Recommendation Report for Planning Permission for Works or Extension to a Dwelling

REF NO: EP/104/21/HH

LOCATION: 8 Selhurst Close
East Preston
BN16 3SR

PROPOSAL: Conversion of garage to habitable use, new garage & single storey extension to West elevation.

Drawing no 11893-2v

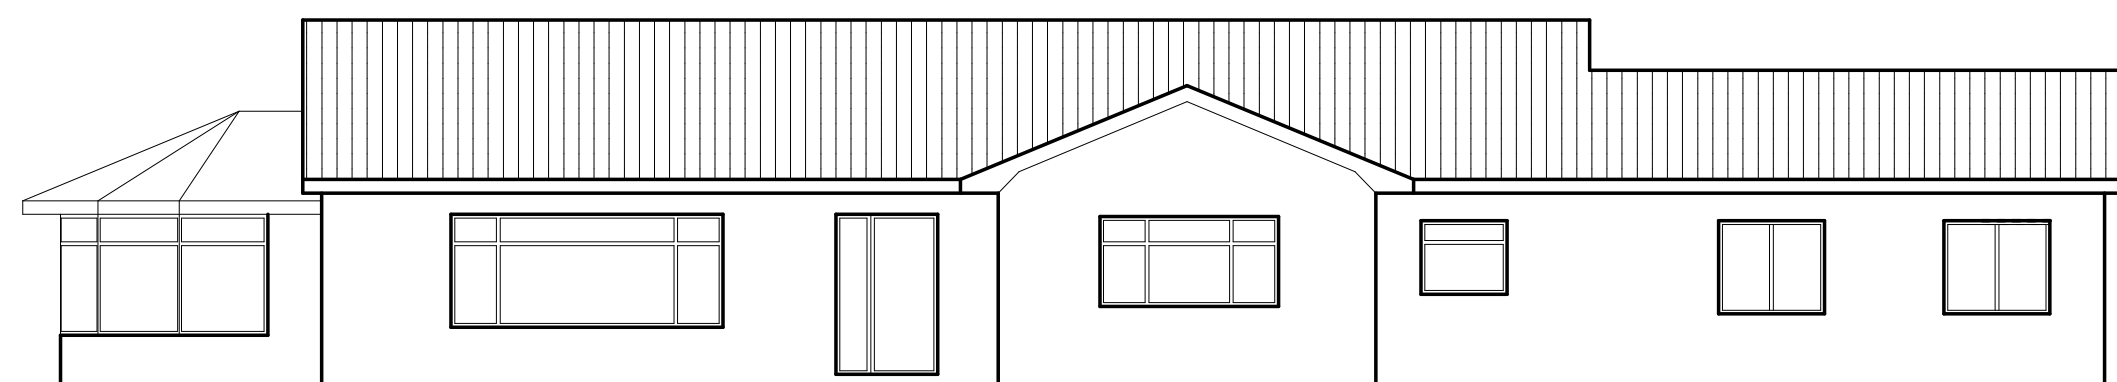
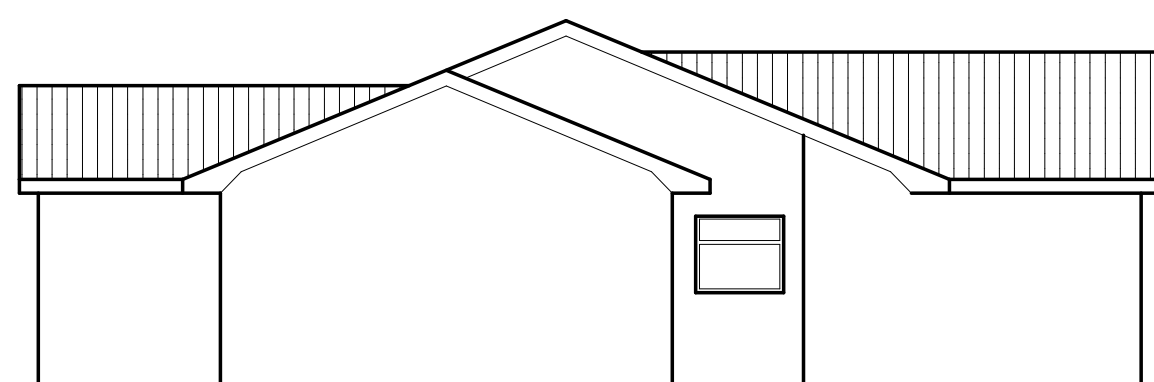
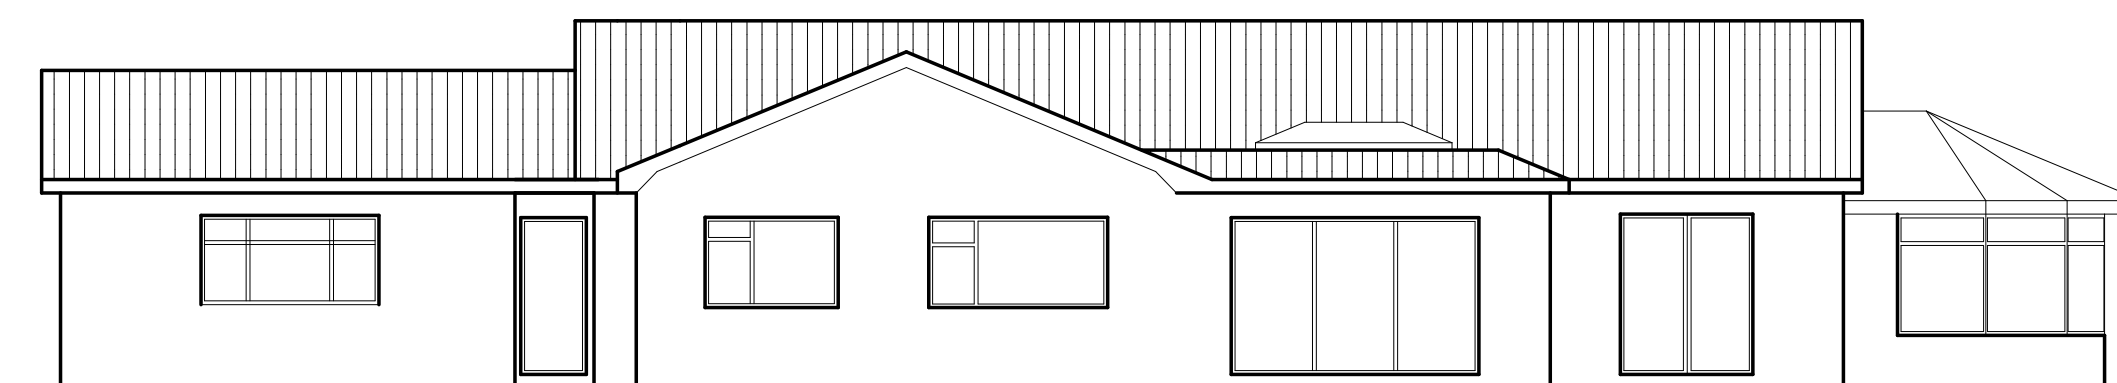
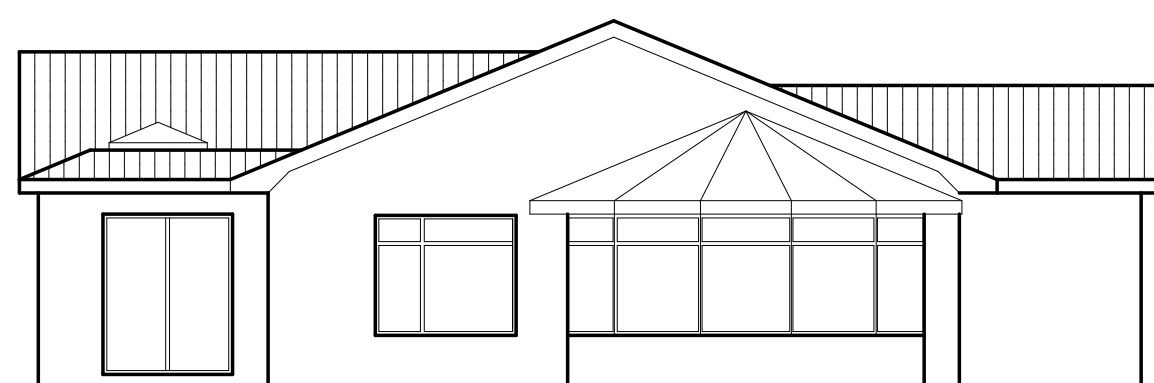
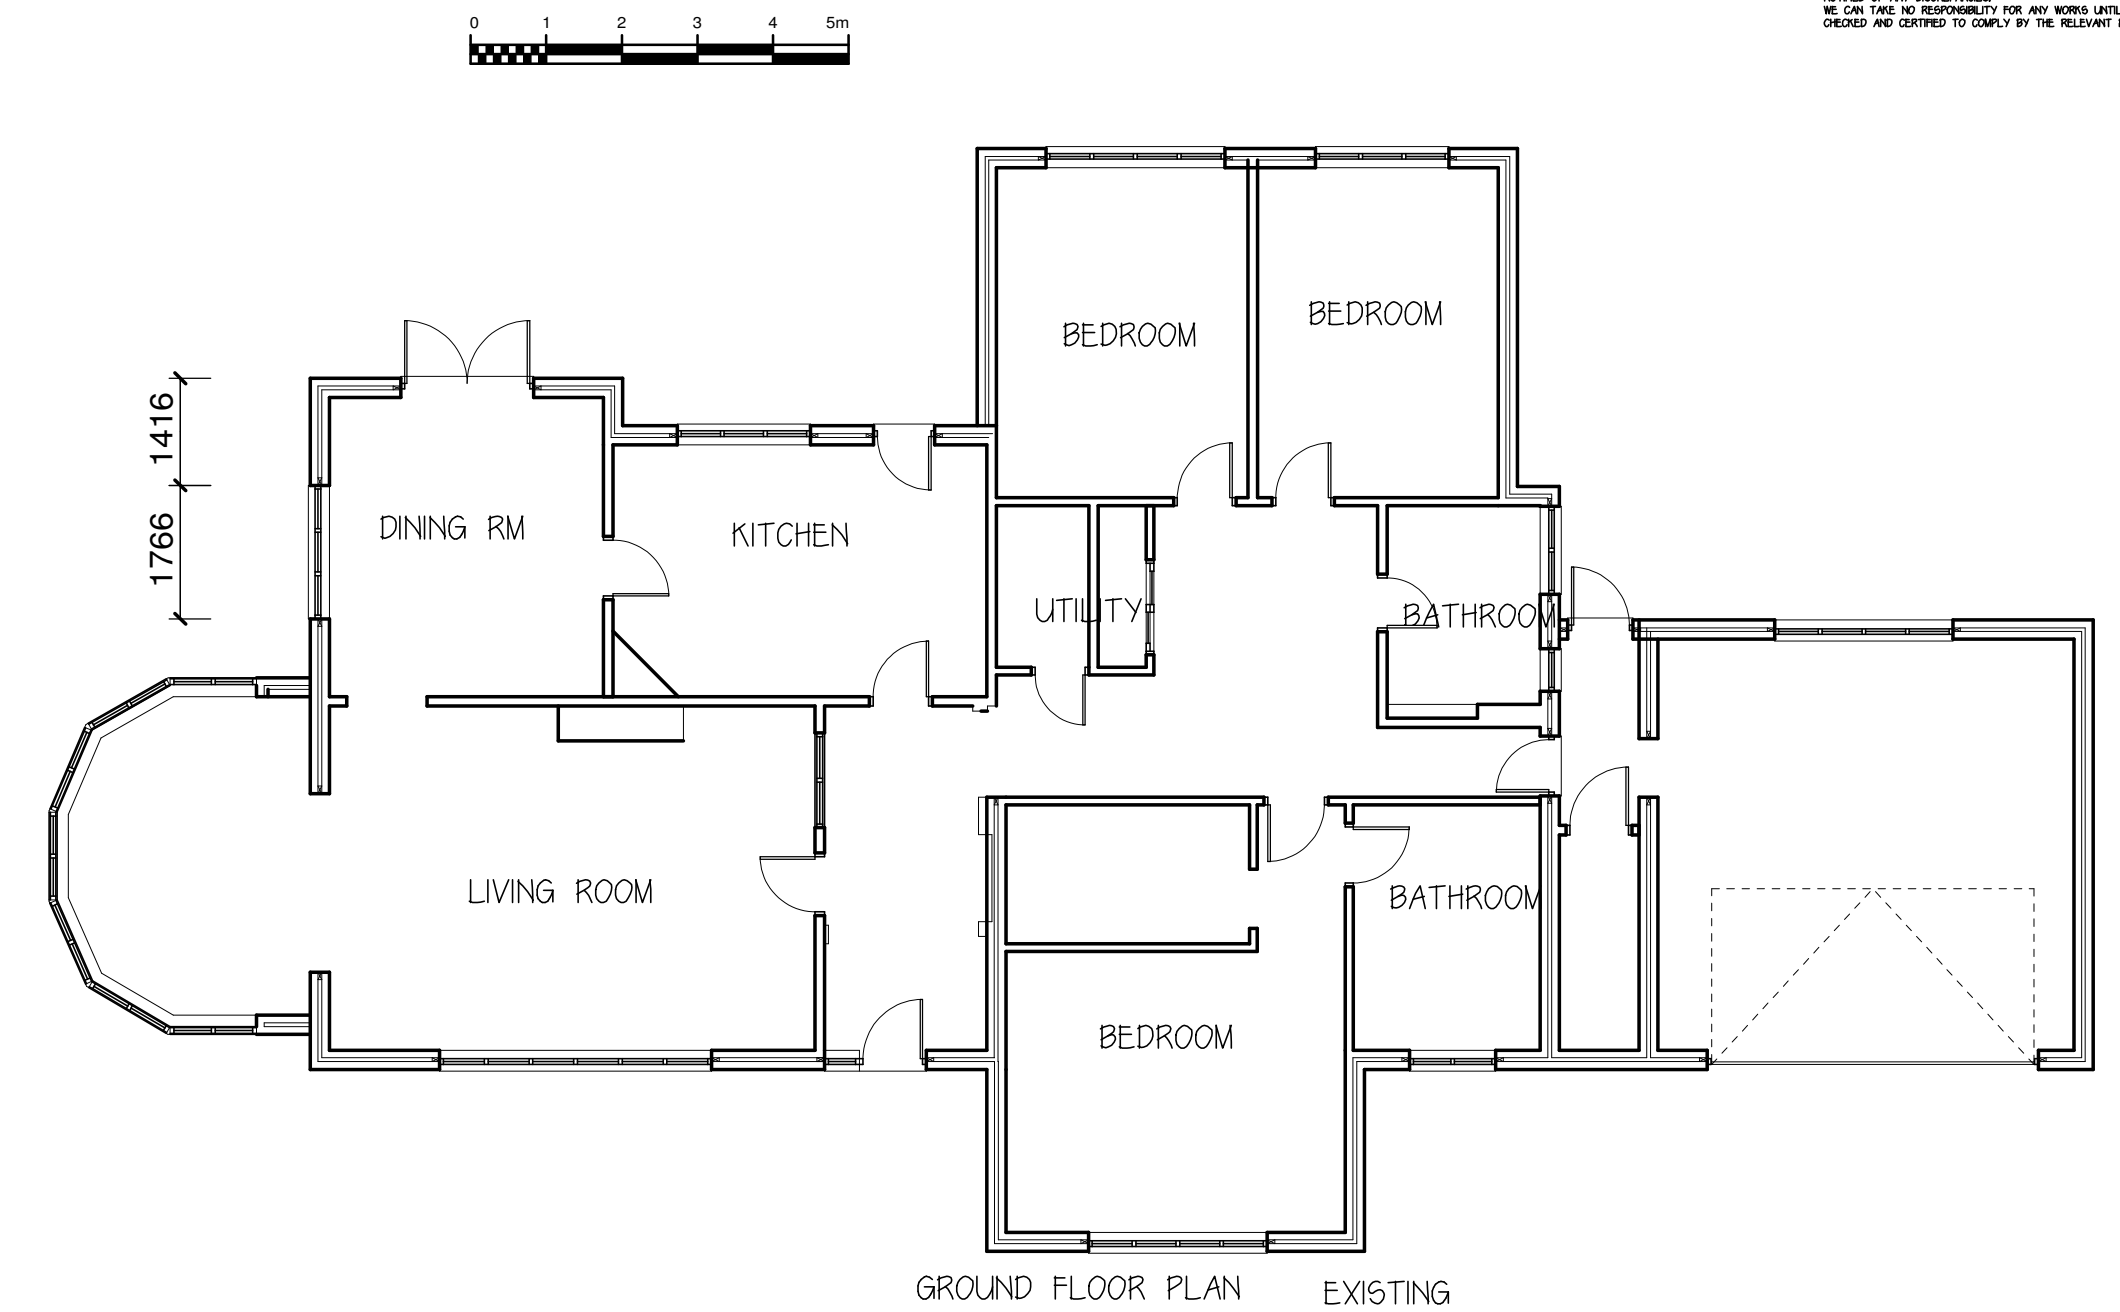
Due to mature planting and a high garden wall views of the rear extension will be restricted, as such the rear extension is not considered to compromise the character of the area.

Views of the garage conversion and proposed double garage will be possible from Myrtle Grove. The alterations to the fenestration to the front of the property are considered minor and would fall under the properties Permitted Development allowance. The garage will be set forward of the next door neighbour's (No.10 Myrtle Grove) building line by approximately 2.5m. Given that the building line of Myrtle Grove isn't particularly strong, this is not seen as a reason to refuse the application. Due to the garages location at the back of site when viewed from Selhurst Close and against the back drop of the buildings in Myrtle Grove, it is considered not to compromise the spatial character of the area.

In terms of overlooking there are no windows proposed above ground floor level, and those which are proposed, face the private amenity space of the host dwelling or towards the public realm, as such no negative impacts from overlooking are foreseen.

The extension will be located centrally within the site and the 45-degree rule in this instance is not applicable.
